Our ref: **SHARE 20040073**
Your ref: **TR050007**

Planning Inspectorate

APPLICATION BY TRITAX SYMMETRY (HINCKLEY) LIMITED (“THE APPLICANT”) SEEKING DEVELOPMENT CONSENT FOR THE PROPOSED HINCKLEY NATIONAL RAIL FREIGHT INTERCHANGE PROJECT (“THE PROPOSED DEVELOPMENT”)

This submission forms National Highways’ response following a review of the additional information provided by the Applicant to Secretary of State on 10 December 2024.

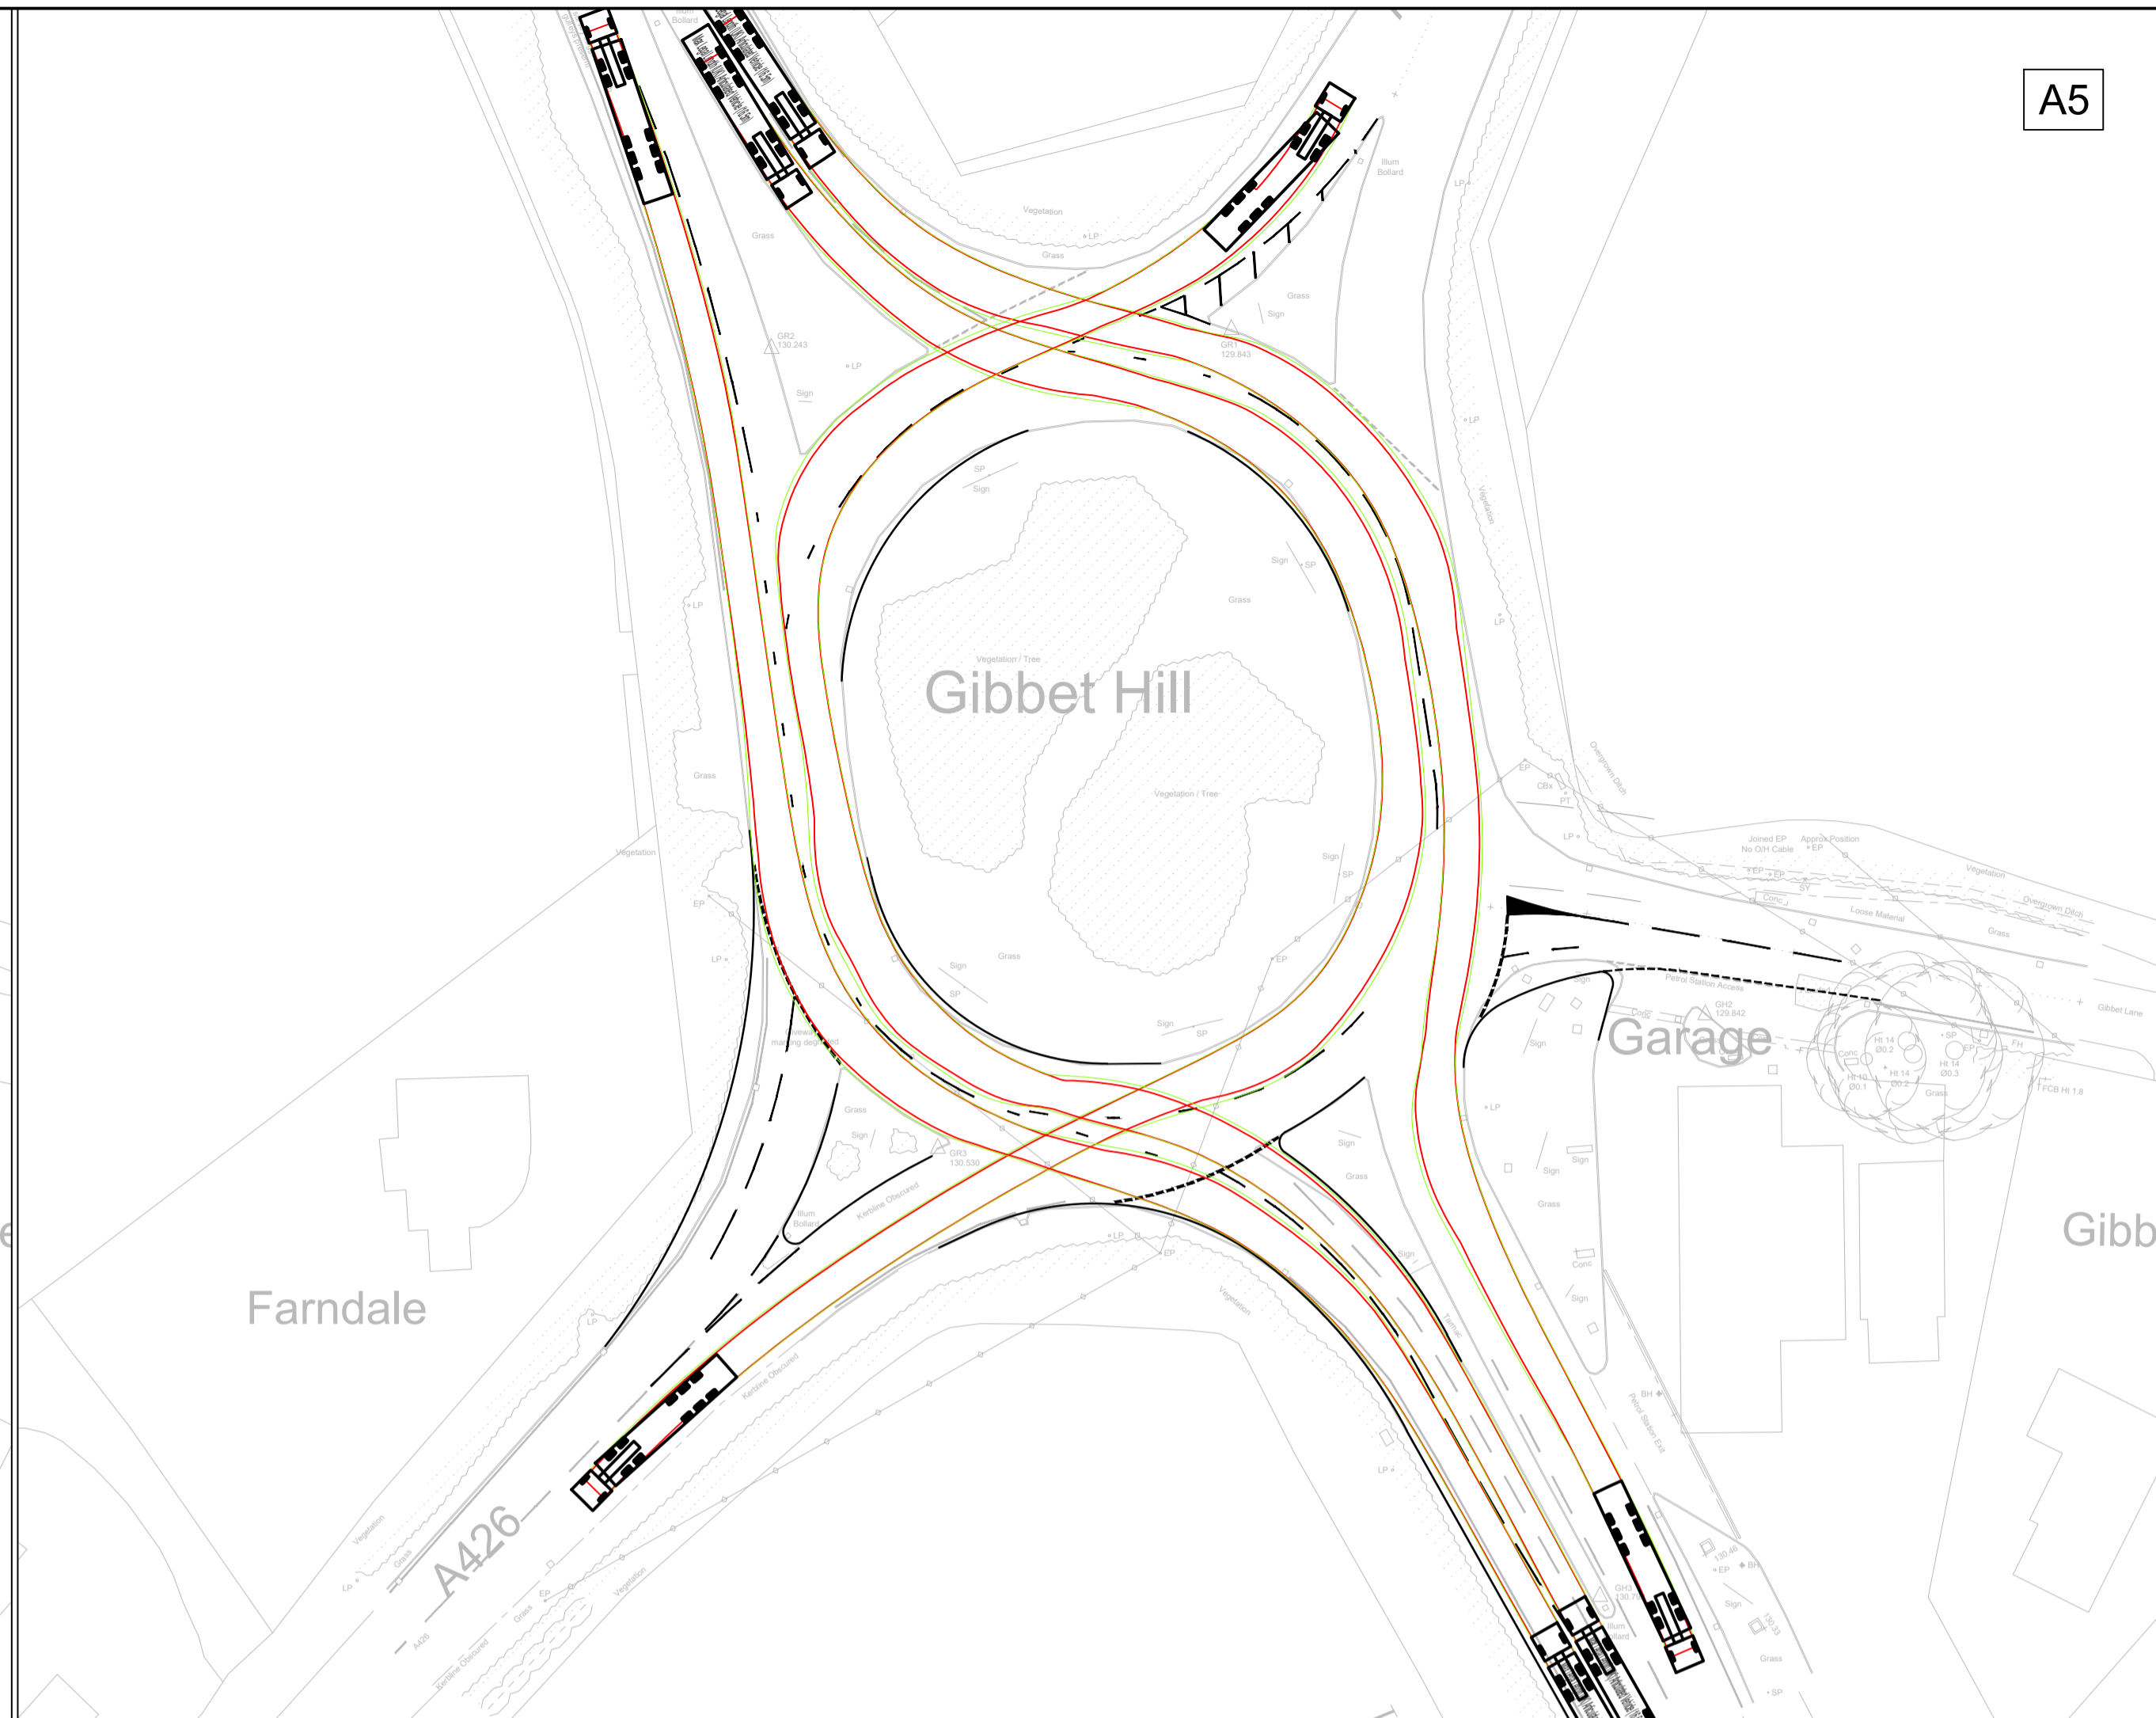
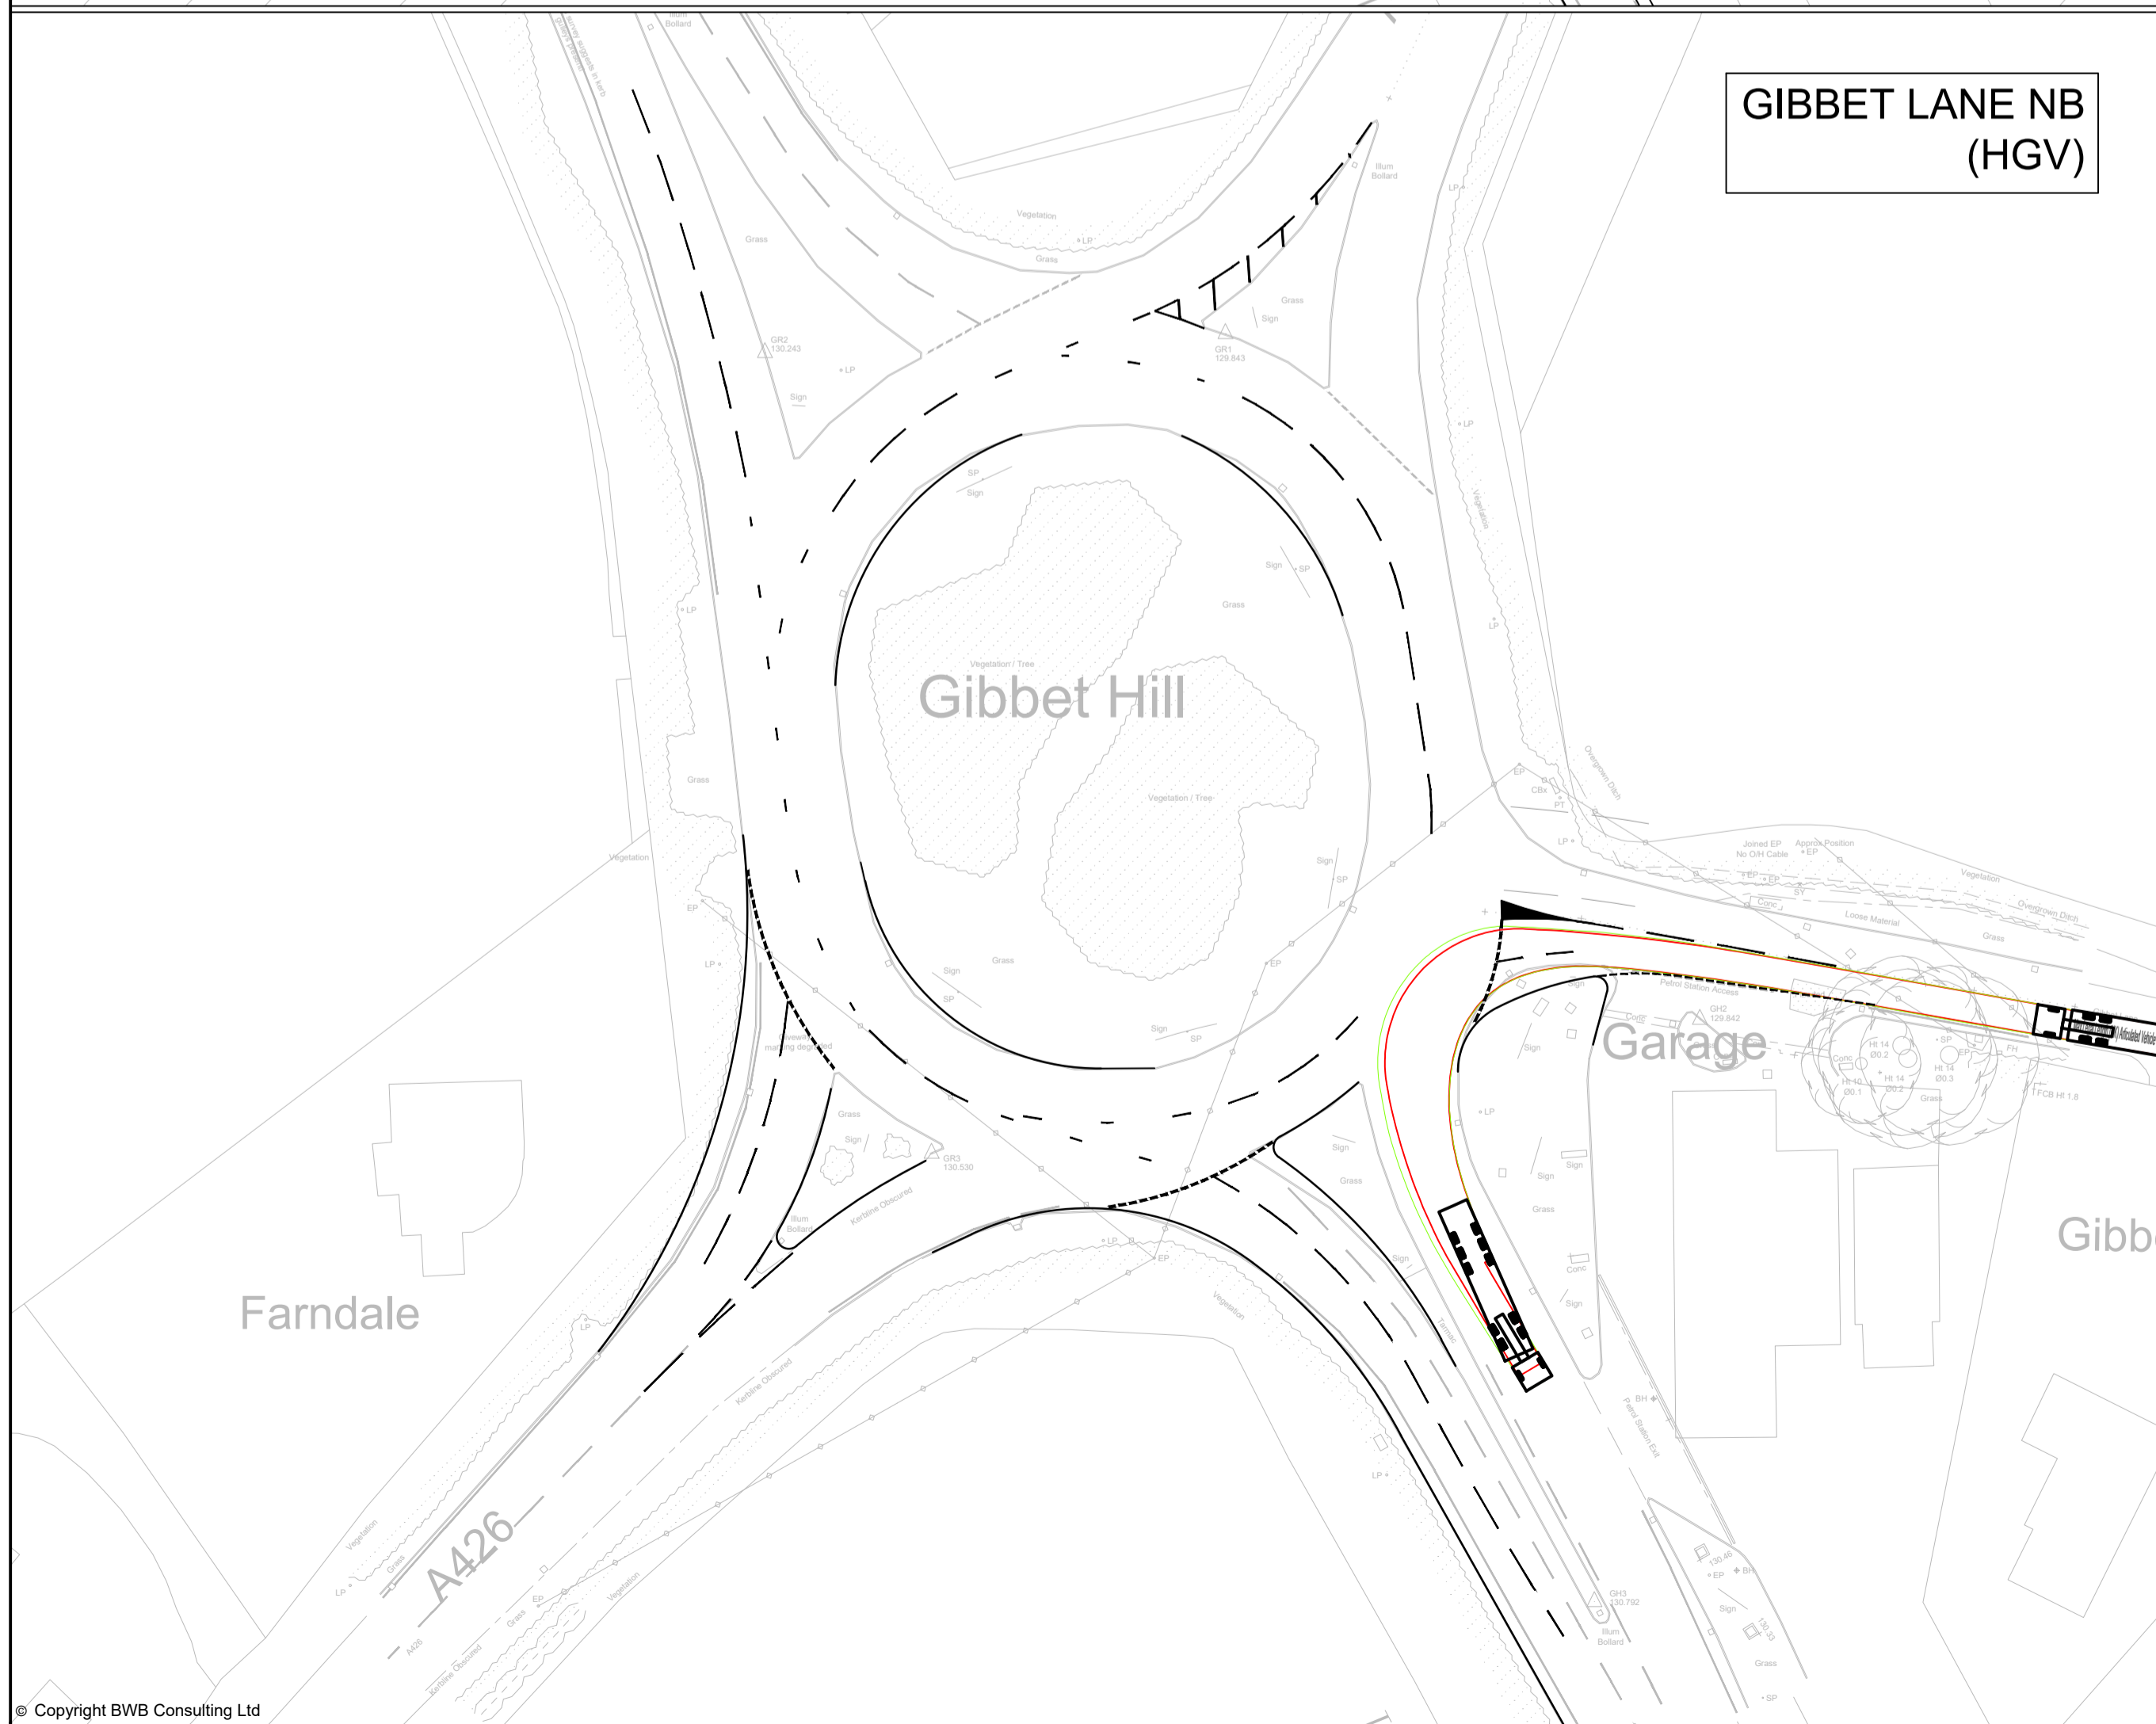
Considering the proposed mitigation scheme is meant to enable two HGV's to route side-by-side around the circulatory, we remain concerned that it has not been suitably demonstrated that this can be safely accommodated. The Applicant has submitted a swept path analysis showing how vehicles shall track the circulatory, however this does not demonstrate sufficient clearance to address this concern.

Should HGV drivers consider this side-by-side manoeuvre unsafe, this results in effectively only one of the two lanes at the A5 south approach being available to HGVs. As the Junctions 10 model assumes HGVs can use both lanes, the model results in this case would underestimate the suitability of the proposed scheme to mitigate the development's traffic impacts at this A5 approach.
